## **TOWN AND COUNTRY PLANNING ACT 1990**

### **FULL**

<b>Reference:</b>	H02-1171-25	<b>Date of Decision:</b>	22nd January 2026
<b>Applicant:</b>	Mr P Blackbird C/O Remway Design Ltd Middledene Surfleet Road Pinchbeck PE11 4AG		
<b>Location:</b>	Rear Of 12 Peterborough Road Crowland		
<b>Description:</b>	Proposed Bungalow & Garage

### BLOCK PLAN OF PROPOSED DEVELOPMENT

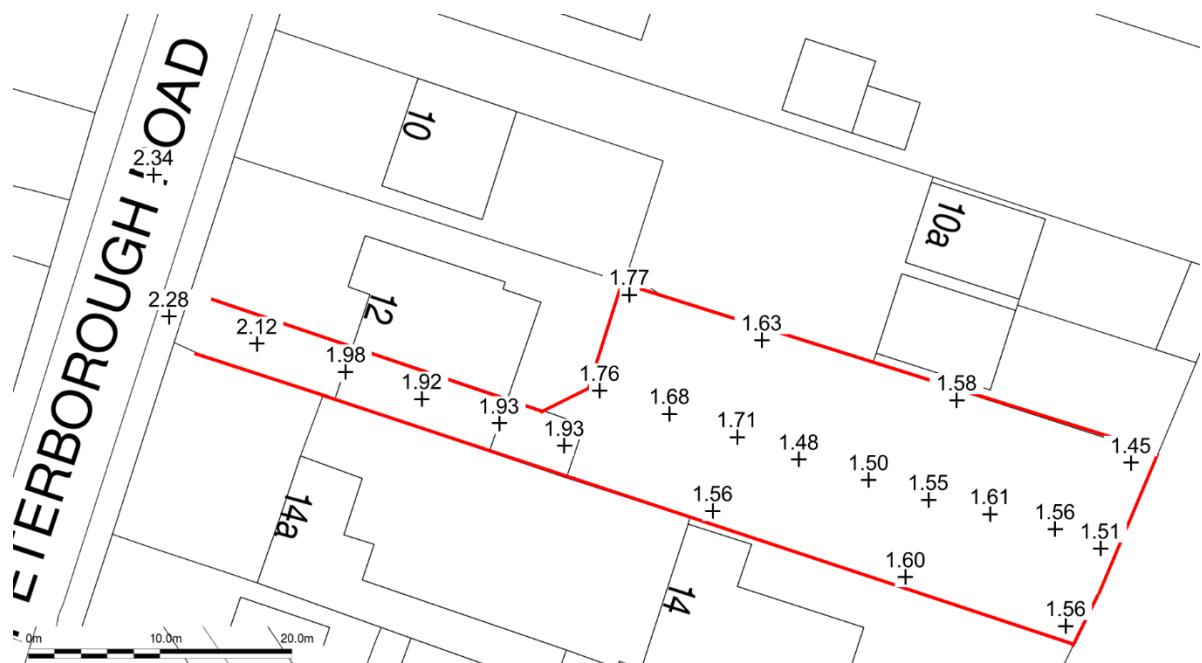
1 The proposed dwelling is considered to represent an incongruous form of development, at odds with the established character of the area, due to its significant scale in relation to the associated frontage properties. Peterborough Road has a consistent frontage-to-backland relationship, with the backland developments being visually subservient, due to a reduced scale, to the frontage elements. The proposal, due in part to the need to significantly raise finished floor levels, would break this established pattern, resulting in an incongruous and overly dominant form of development, judged to be harmful to the character of the area.

Elevation 01 - Front
1 : 100

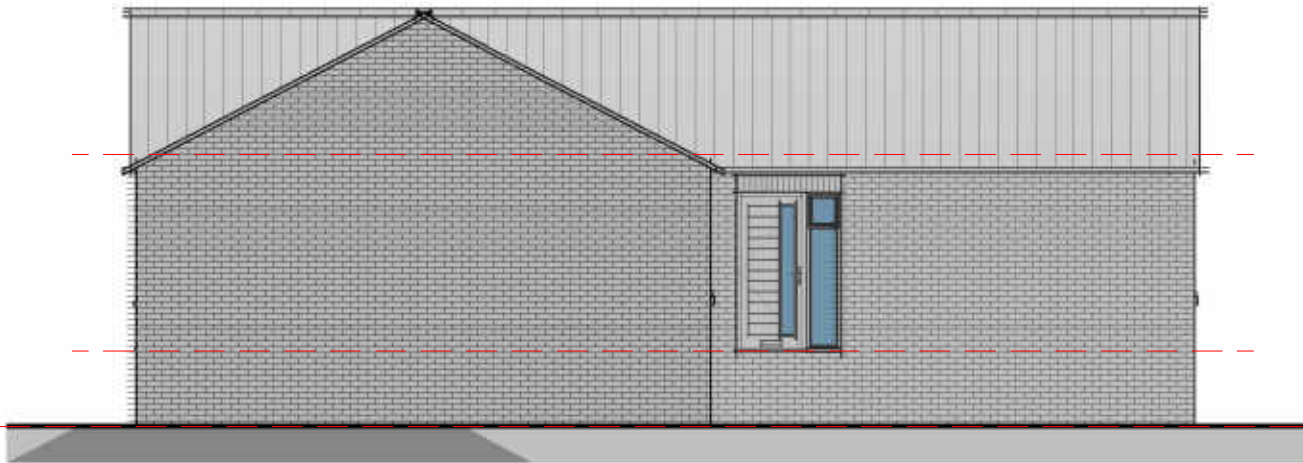
- 3 It is considered that the proposal, due to the need to raise finished floor levels substantially, would significantly and detrimentally overlook neighbouring dwellings; thereby impeding upon the amenity enjoyed by the occupants of these dwellings.
